Linked NSIP (LINCS Reservoir, planned water supply for approx. 500,000 people) Not Being Considered in ES, EIA, cumulative and in-combination effects.

Verbal submission made and further supporting information

Figure 2-1: Main Rivers and Ordinary Watercourses within Study Area

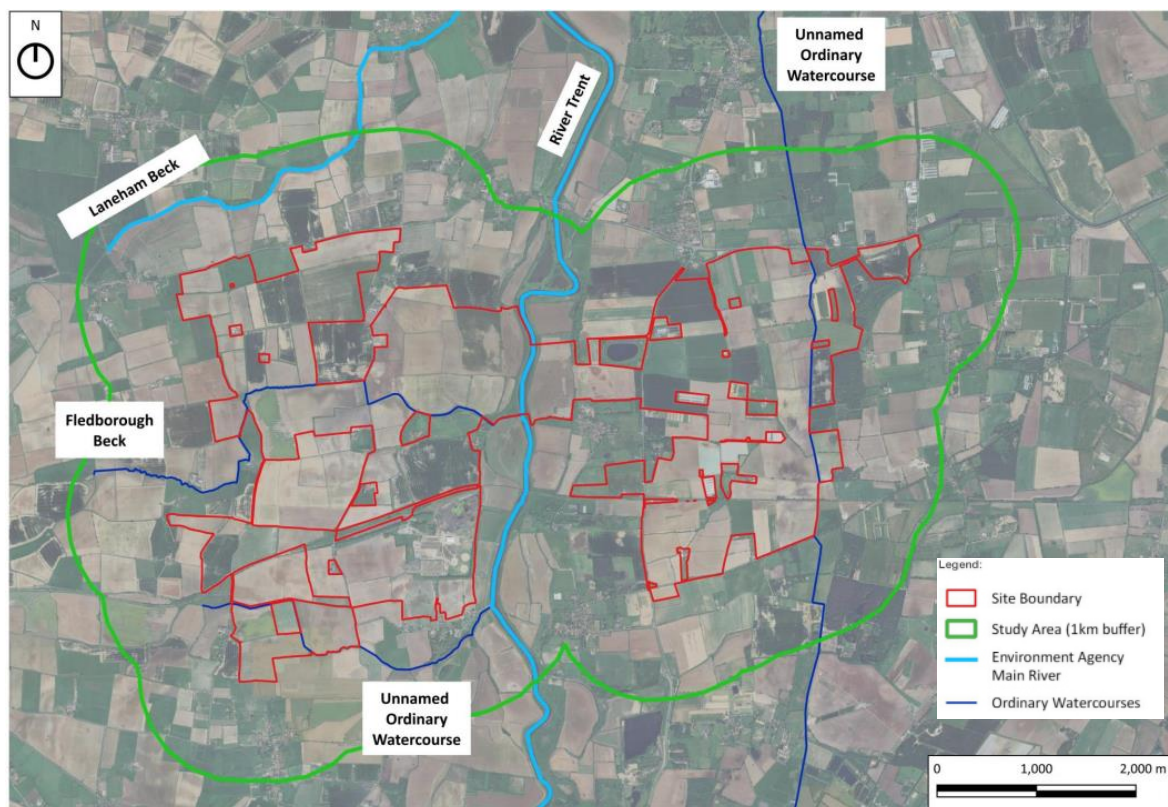
- **Chapter 7: Hydrology & Hydrogeology** assesses local rivers and watercourses but limits its study area to a 1 km buffer around the site and does not consider downstream abstraction infrastructure.
- **Appendix 7.4: Water Framework Directive Screening Assessment** concludes no impact to waterbodies but makes no mention of the LINCS Reservoir or linked abstraction points.
- **Chapter 18: Cumulative Effects** and **Appendix 18.2: Long List of Other Developments** list many local and regional projects, but there is no entry for the proposed LINCS Reservoir or comparable downstream water supply infrastructure.

This absence suggests that the potential cumulative and hydrological link between OESF and the LINCS Reservoir has not been explicitly assessed or disclosed in the ES.
